Submission for Job: #6011 SSD 6011 - Mixed use residential development within the South West Plot
https://majorprojects.affinitylive.com/?action=view_job&id=6011

SSD 6011 - Mixed use residential development within the South West Plot

23 July 2013

## Winter Solstice (21<sup>st</sup> June)

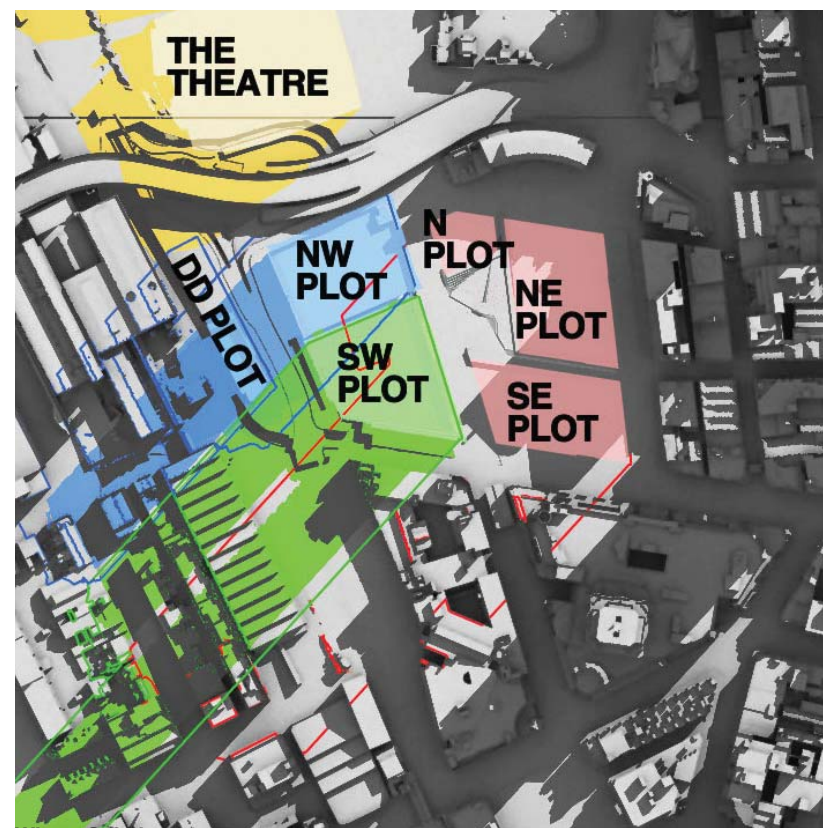
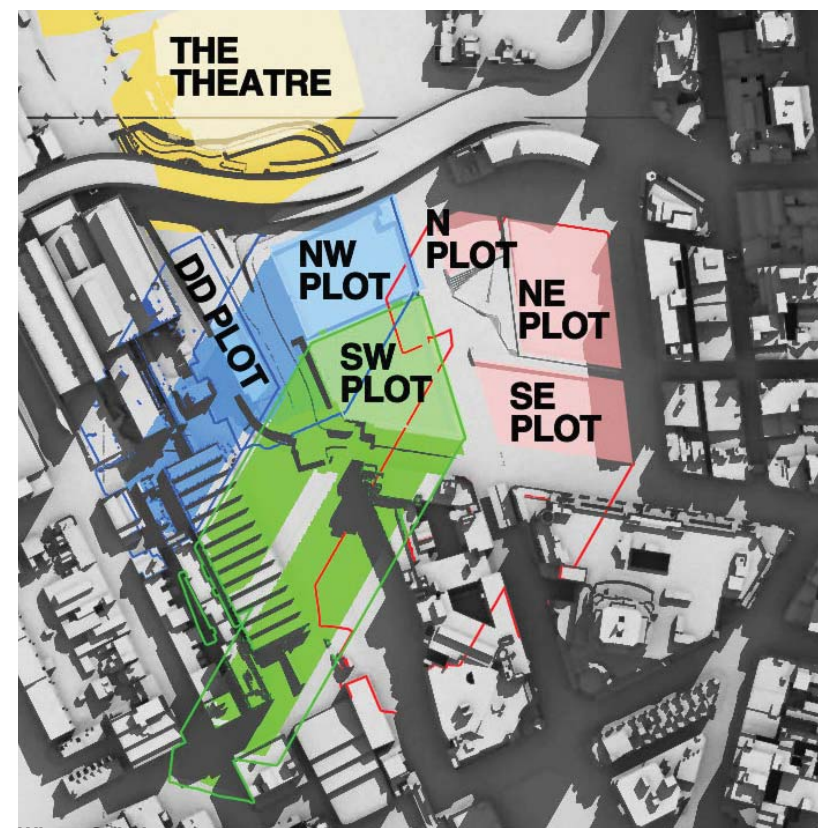
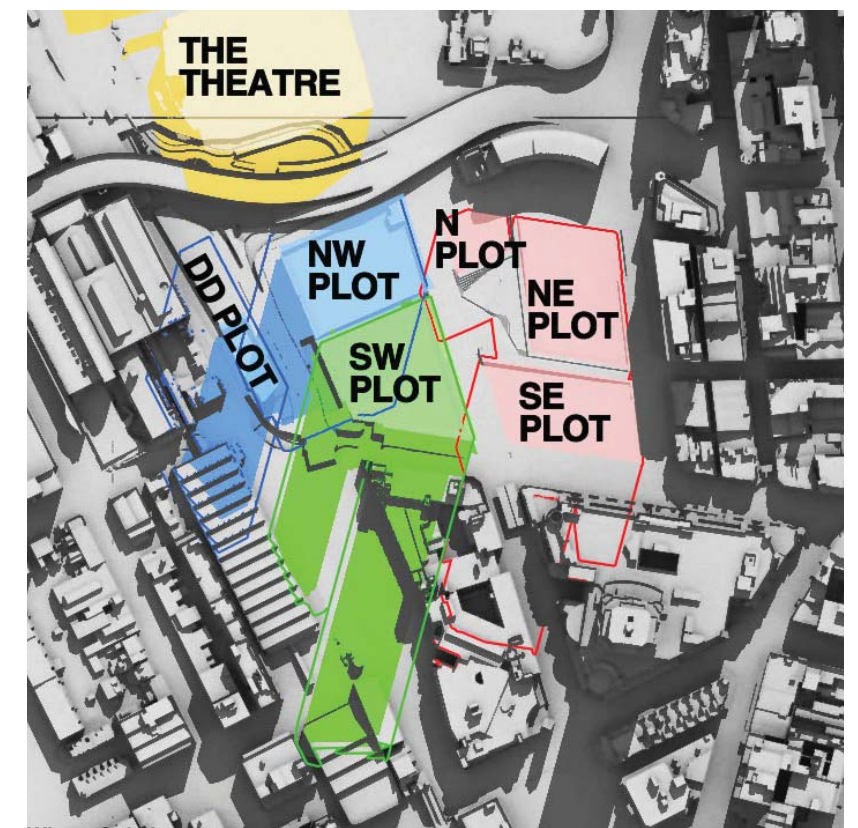
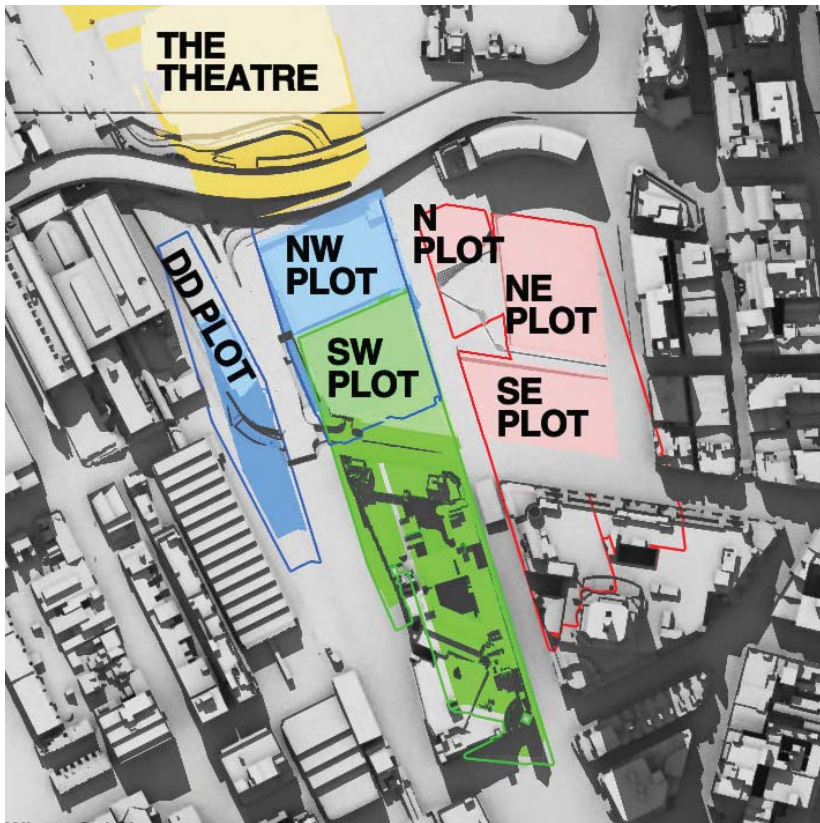
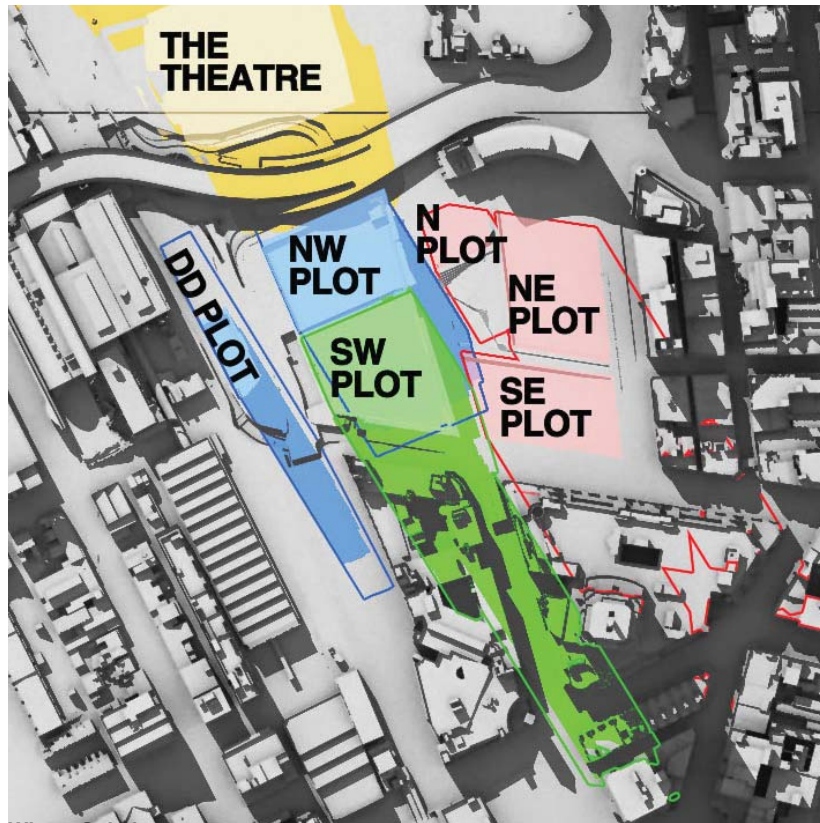
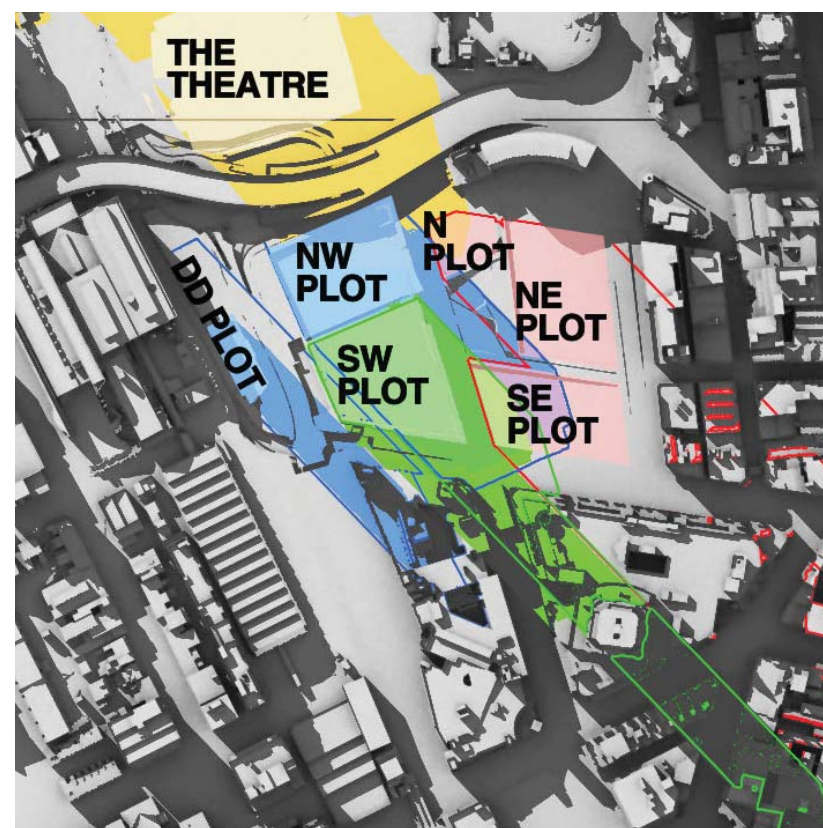
At 9am, 10am and 11am the west façade is totally in shadow due to other parts of The Peak building itself.

At 12pm there is still substantial existing shadowing on the west façade caused by the irregular shape of the west facade.

At 1pm the existing shadowing has been substantially removed, but not totally removed.

It can be concluded that some single aspect apartments on the west façade and some south-west dual aspect corner apartments currently receive less than 2 hours direct sunlight to habitable rooms and 50% of the private open space between 9am and 3pm on 21 June.

By 2pm the existing shadowing has been totally removed, but that is too late to achieve two hours of direct sunlight before 3pm.

At 9am, 10am and 11am the west façade is totally in shadow due to other parts of The Peak building itself.

At 12pm there is still substantial existing shadowing on the west façade caused by the irregular shape of the west facade.

At 1pm the existing shadowing has been substantially, although not entirely, removed. However, overshadowing of lower levels of the west façade by the concept proposal parameter plan shadows for the N,NE and SE plots has already started.

By 2pm the existing shadowing has been totally removed. However, overshadowing of the west façade by the SSDA4 and SSDA5 buildings has appeared and risen further up the west façade than the concept proposal parameter plan shadows for the N,NE and SE plots, which is still present.

At 3pm, the proponent states correctly that 45-45% of the western façade is overshadowed by the SSDA4 and SSDA5 buildings.

It can be concluded that, as a result of combination of the proposed development with existing shadowing of the west façade, some single aspect apartments on the west façade and the south-west dual aspect corner apartments which currently receive less than 2 hours direct sunlight to habitable rooms and 50% of the private open space between 9am and 3pm on 21 June will suffer additional overshadowing. It is beyond our skills to count the number of such apartments. We note that the proponent has made no attempt to do so.
